Application for a Non-Material Amendment Following a Grant of Planning Permission

Construction of a four storey, Single Living Accommodation building (Use Class C2a), associated external works and erection of ancillary buildings (following demolition of Building 314).

DC/22/04231

Non-Material Amendment(s) Sought

Title
HARD LANDSCAPING PLAN-XX-G00400-XX

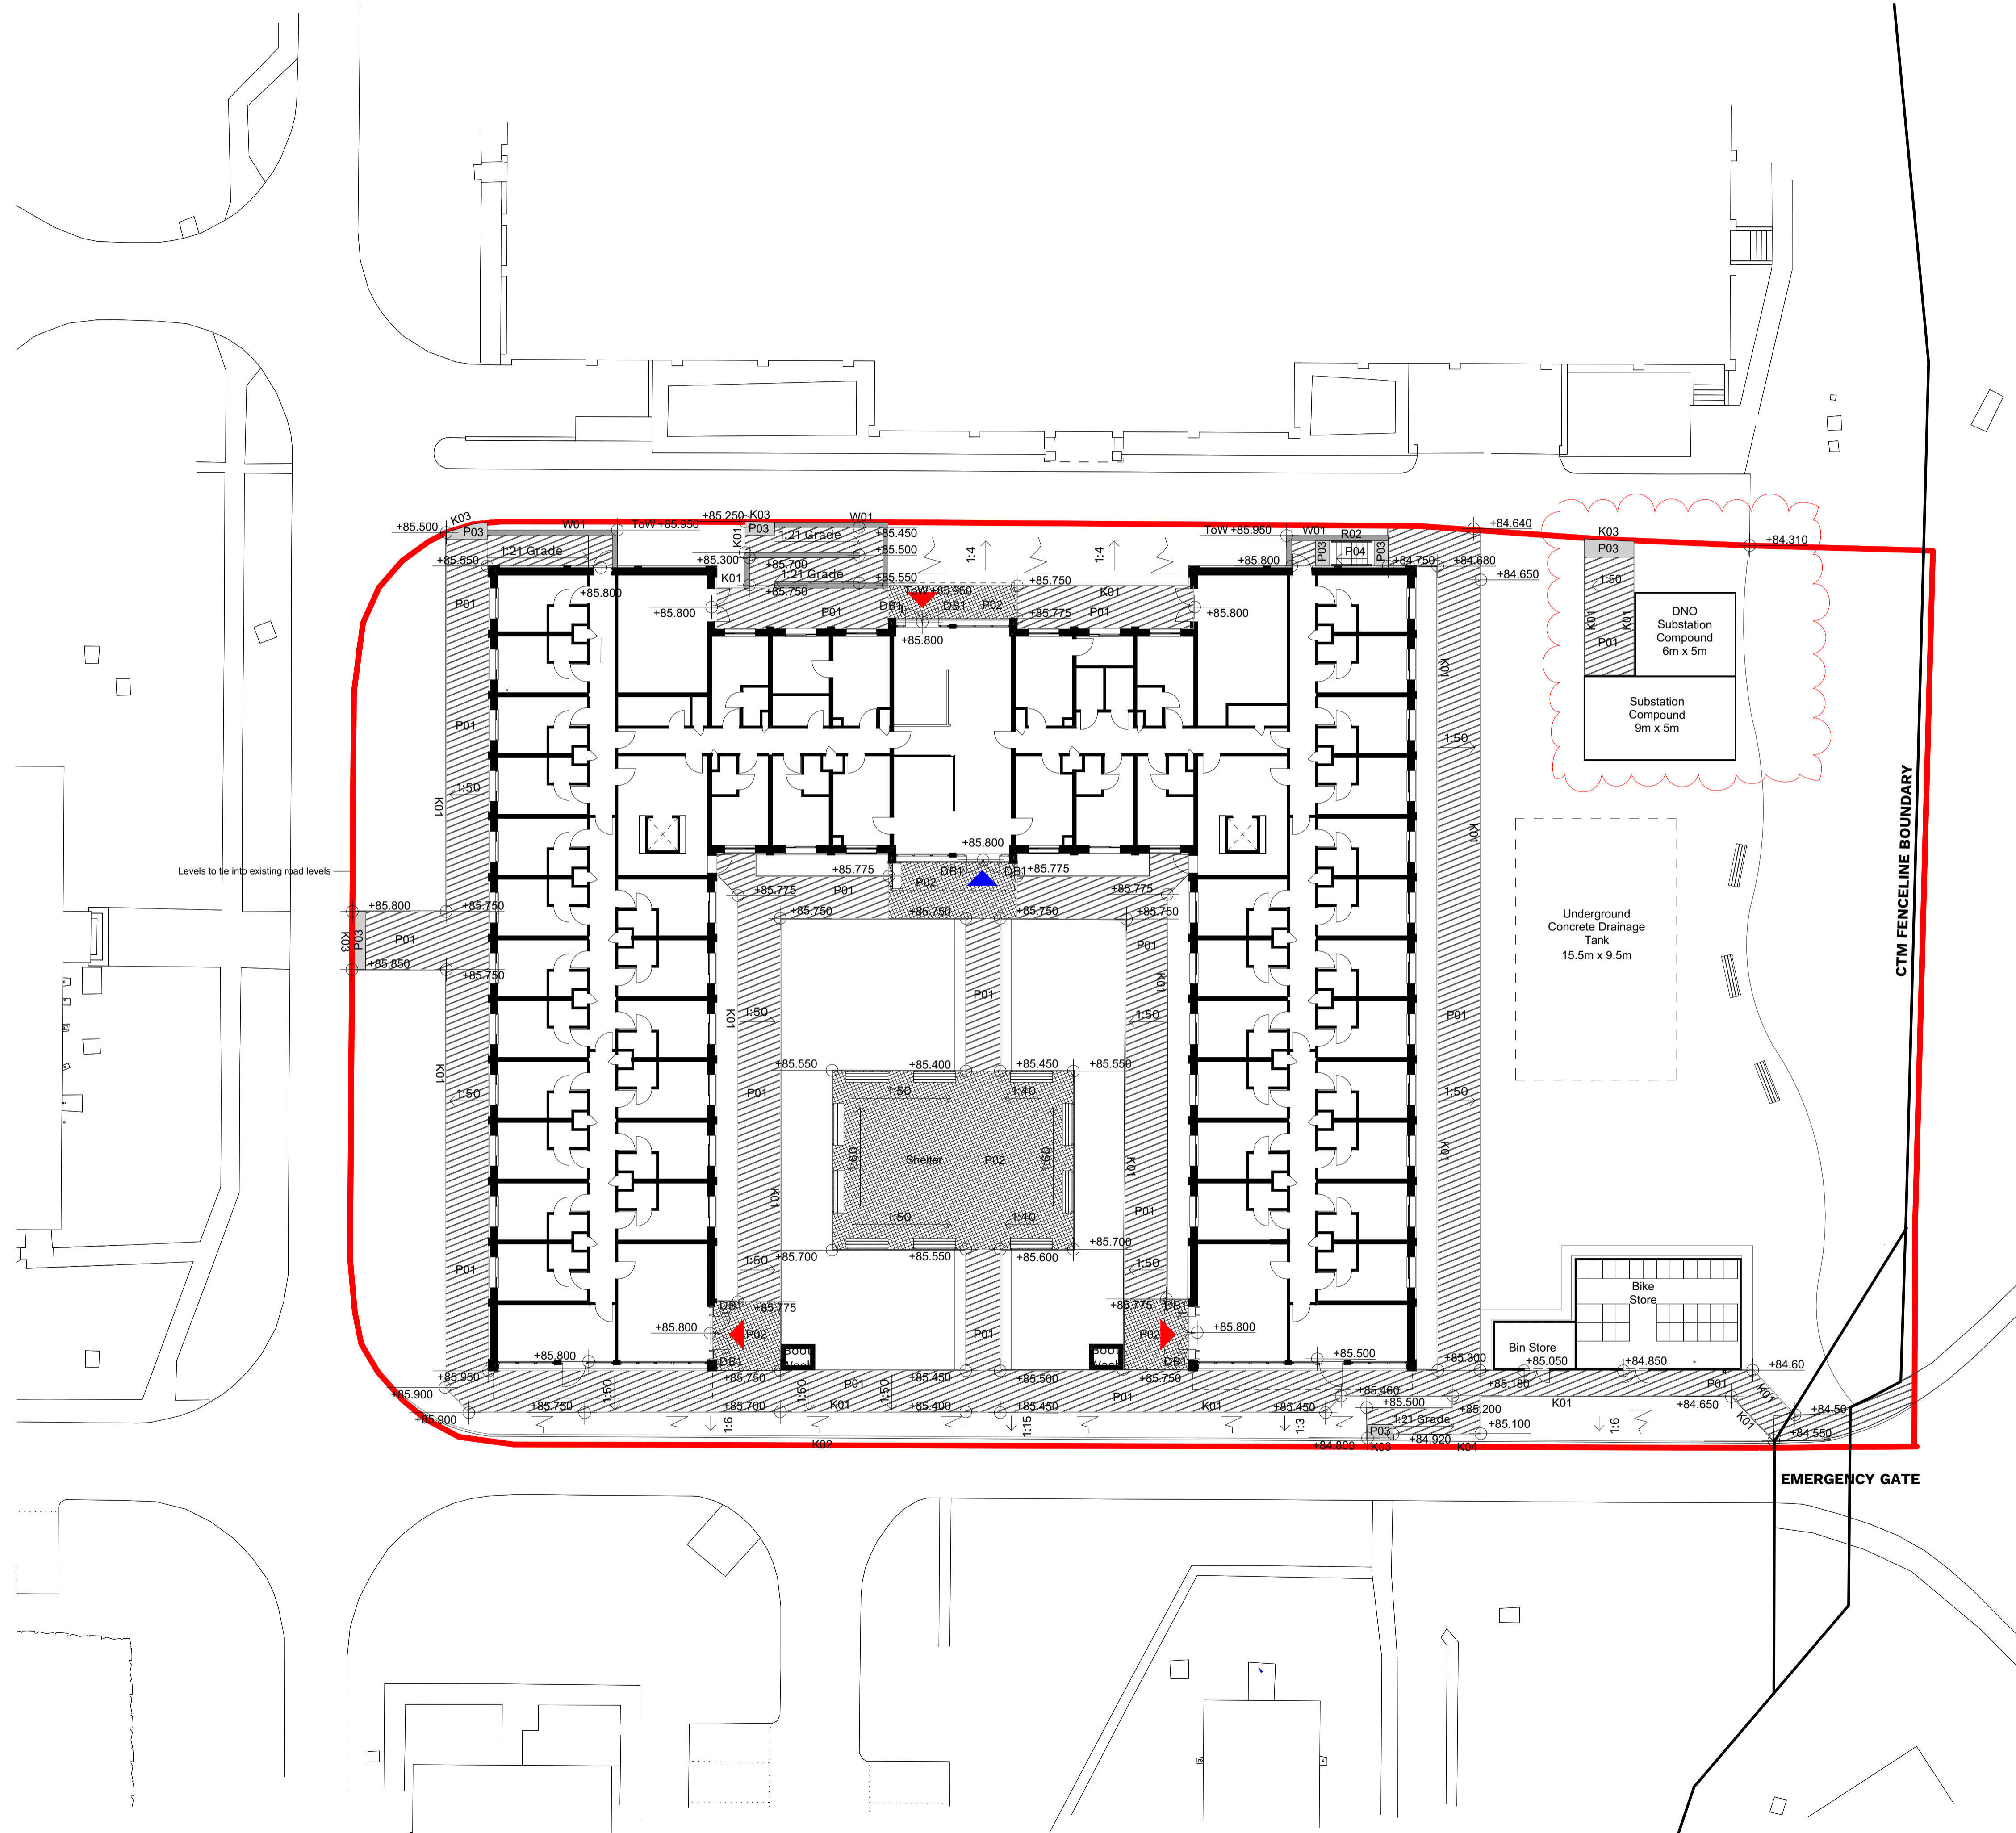
1. Revised Drainage Layout - Variations to the drainage layout to suit unknown existing site services.
2. ASHP compound - moved from ground level to the roof of the accommodation block.
3. Substation – a new electrical substation is required to service the accommodation.
4. Updated Site layout – to reflect ASHP compound move to roof and addition of a sub station.
